**Job name:** Prickleden Mill

**Job No:** B24120-JNP-XX-XX-RP-C-1002

**Date:** 12/07/2021

**Subject:** Response to EA & LLFA Comments

Figure 5.2: Areas Susceptible to Flooding up to the 1 in 100 Year + CC Level Pre-Development

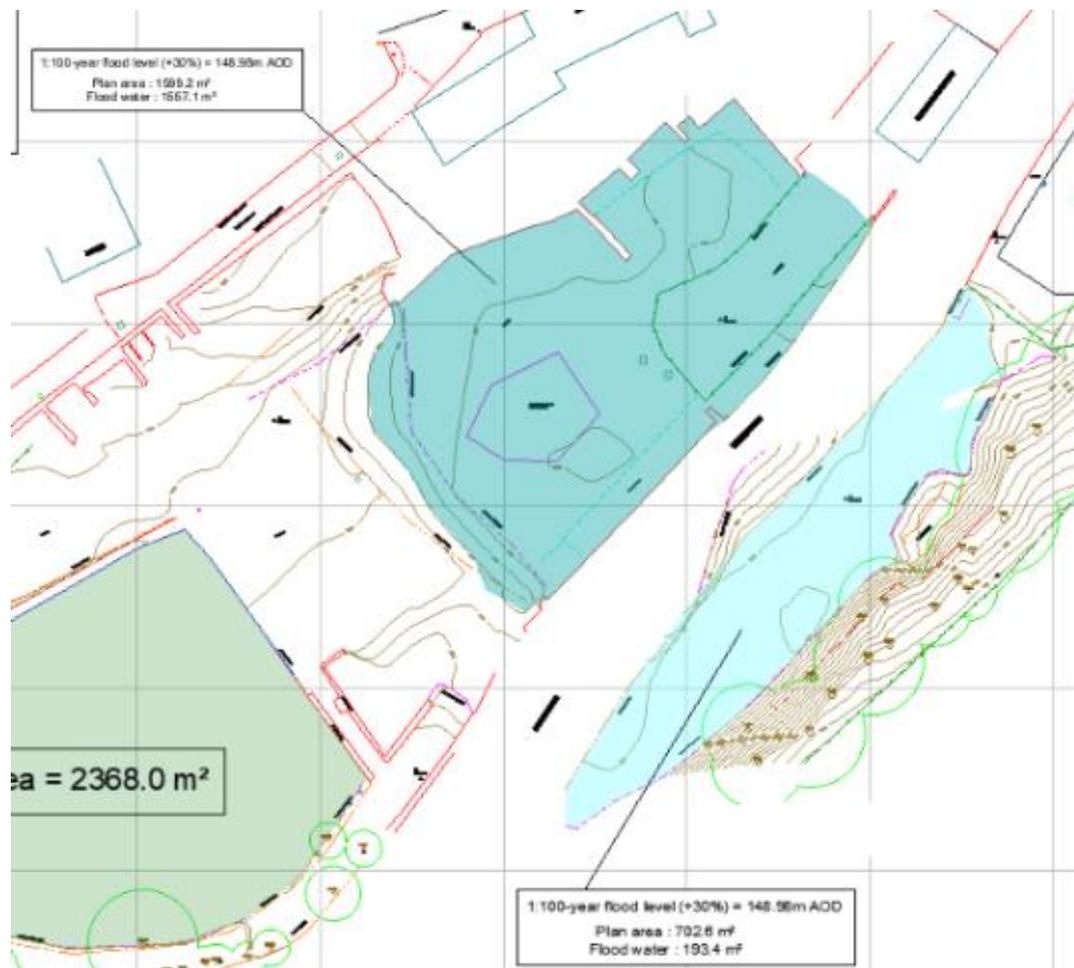
**1.1.31** The pre-development enquiry and figure 5.2 of the FRA indicate part of the lounge is cantilevered over the mill pond. As this is a private asset the suitability of this should be discussed with the Flood Risk and Drainage Teams at Kirklees Council. The FRA should demonstrate this is above the 1% plus climate change level plus 600mm and demonstrate there is no loss of flood storage to this level.

**1.1.32** The FRA needs to demonstrate i) that there is no loss of storage (up to the 1% plus climate change level) as a result of the wall around the lounge, and ii) no alteration of existing flood flow routes that would transfer flood risk to others. The FRA suggests raising of the dam wall will direct water from this area to the south east, the FRA needs to detail any proposed changes in level to the existing walls around the mill pond and to what height, and demonstrate no loss of storage or transfer of flood risk to others.

**1.1.33** As the residents lounge is in FZ1, compensation for lost storage is not required. Similarly flood routes not impacted. Details of amendments to dam need to be supplied to EA and potential impact of these works assessed.

Figure 5.4 Location of Undercroft Car Park

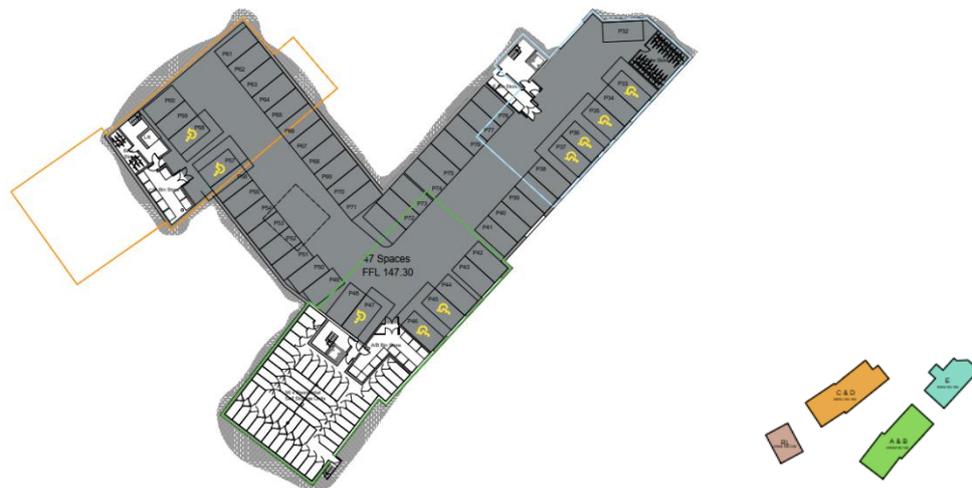
- 1.1.19** Basement car parking uses The scheme approved for the site in 2018 did not include the need for compensatory storage in basement parking voids. Creating a basement parking area to flood at the 1 in 10 year return period creates an additional flood hazard to the site and potential risk to life which currently does not exist, and did not exist in the previous scheme approved for the site.

- 1.1.20** Our preference would be for the removal of the basement areas and to seek car parking in other areas of the site. A basement below adjacent ground level will fill up with water first in the event of flooding, so should be treated with caution and an emergency plan should be produced for the event of a flood. The Flood Risk Team at Kirklees Council should decide whether this is appropriate. We suggest a

- 1.1.21** Basements must have unimpeded access and be of waterproof construction to avoid seepage during flood conditions. The FRA indicates flood gates on the basements (not used as storage voids) however there is no detail about their height and whether these are to try and stop the basements flooding or to direct water away from areas of the site. The FRA must demonstrate there will be no transfer of flood risk to others as a result of loss of flood storage, or alteration of existing flood flow routes. Flood gates require human intervention to install them, and a trigger such as a flood warning, which we cannot guarantee will have a lead-in time, so we normally recommend passive flood protection.

- 1.1.24** [The basement car park seems to be one of their key issues.](#) Discussion required on whether the proposed basement is necessary, can be sited elsewhere etc. Also whether the proposed buildings can adhere to the sequential approach, ie all in FZ1 (note though that new modelling is being done).
